from
**Southern
Water**

Your ref
BN/66/19/PL

Proposal: Erection of 3 No dwellings.

Site: BN/66/19/PL: - Land off Canal Mews, Barnham PO22 0AB.

Drainage Strategy Drawing

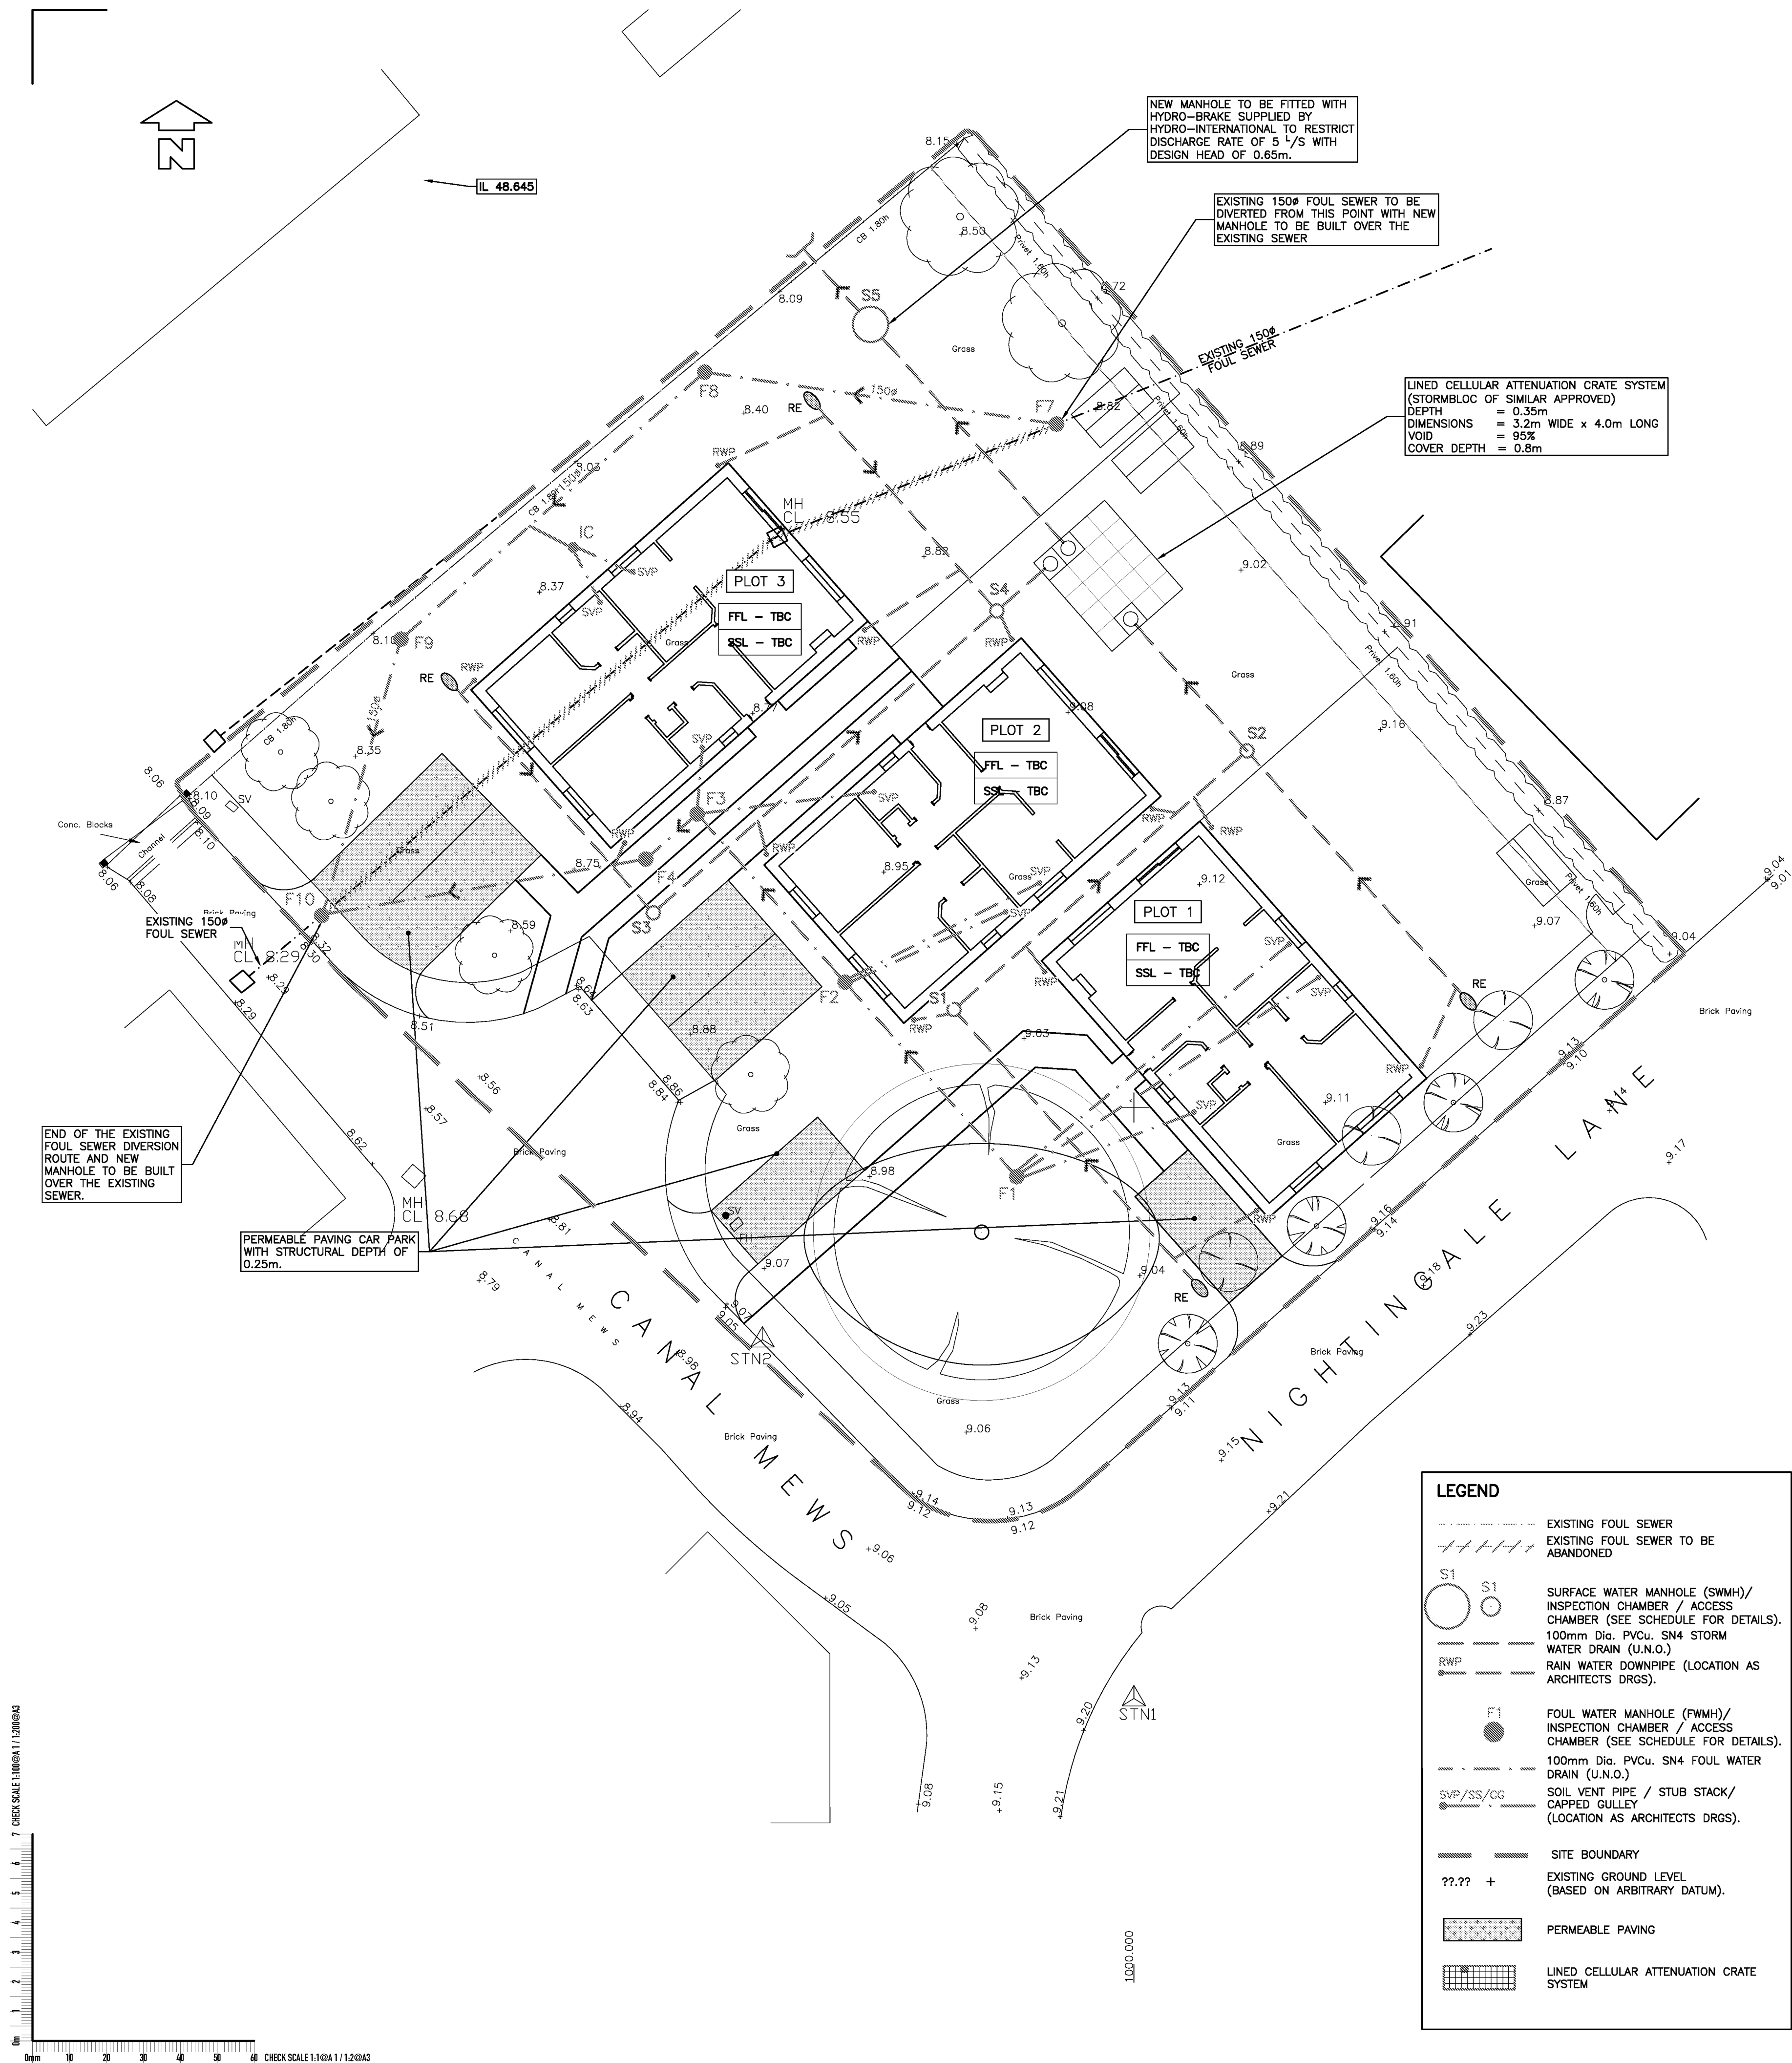
It appears that applicant is proposing to divert public sewer (not shown on our records). Southern Water requests a formal application for sewer diversion under S185 of Water Industry Act 1991 in order to divert any public sewer.

The planning application form makes reference to drainage using Sustainable Urban Drainage Systems (SUDS).

Under current legislation and guidance SUDS rely upon facilities which are not adoptable by sewerage undertakers. Therefore, the applicant will need to ensure that arrangements exist for the long-term maintenance of the SUDS facilities. It is critical that the effectiveness of these systems is

Thus, where a SUDS scheme is to be implemented, the drainage details submitted to the Local Planning Authority should:

- Specify the responsibilities of each party for the implementation of the SUDS scheme.
- Specify a timetable for implementation.
- Provide a management and maintenance plan for the lifetime of the development.
